From: Amanda Scholes on behalf of Planning.Responses
Sent: 06 April 2017 09:22
To: Planning Scanning
Subject: FW: AL/107/16/RES - Land West of Westergate Street & East of Hook Lane Westergate PO20 3TE
Attachments: 20170405-299-AL10716-no_objection.docx

**WEST SUSSEX COUNTY COUNCIL
STRATEGIC PLANNING CONSULTATION**

SUBJECT: AL/107/16/RES - Application for Reserved Matters application following Outline Planning Permission AL/39/13 for the demolition of Oakdene and all other structures within the site and the erection of 79 dwellings, public open space, children's play areas, landscaping, drainage measures, sub-station, pumping station and all other associated works.

Land West of, Westergate Street & East of Hook Lane, Westergate, PO20 3TE

scheme: Hook Lane
Westergate
client: David Wilson Homes
drawing: Hard Landscape Proposals
date: May 2016
scale: 1:200@A1
drawing no: BDWS 20440 12C sheet 2of4
drawn: AE checked: DKM

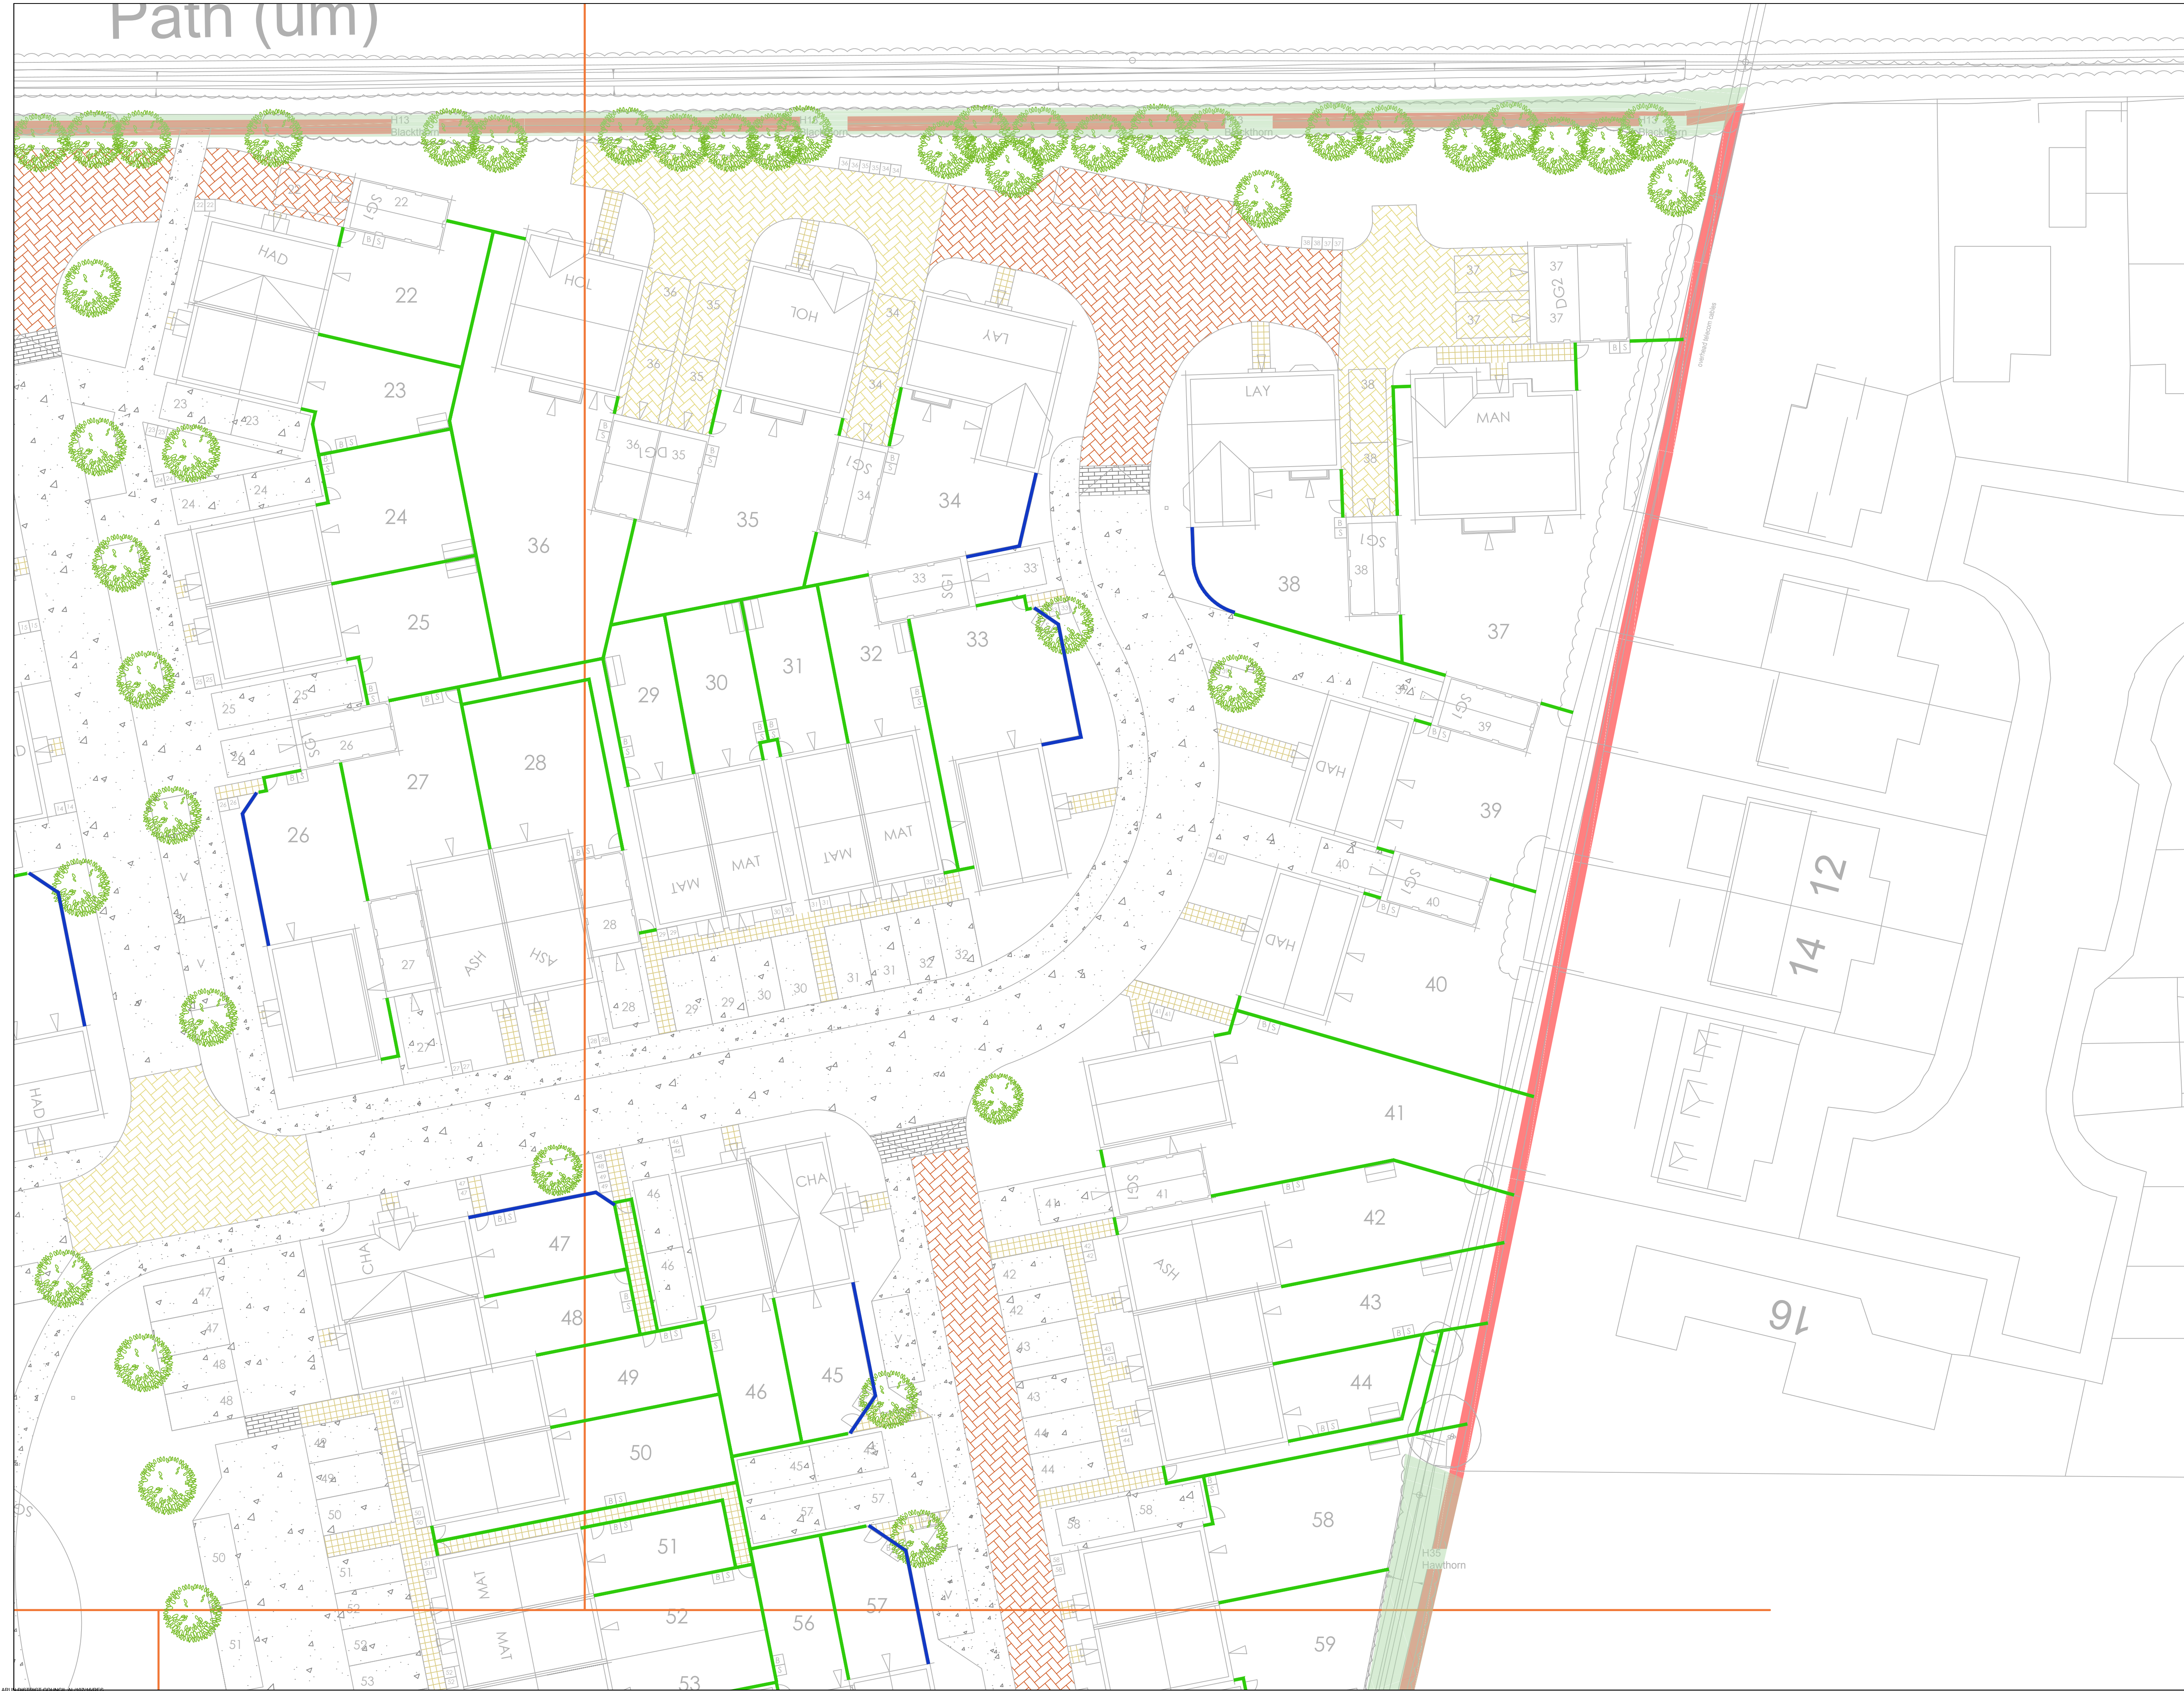
Public Footpath 299 runs outside the northern site boundary. A proposed link path between the development and footpath 299 is shown close to plot 22. The WSCC PROW service considers an additional link path should be provided opposite plot 38 for the convenience of future residents.
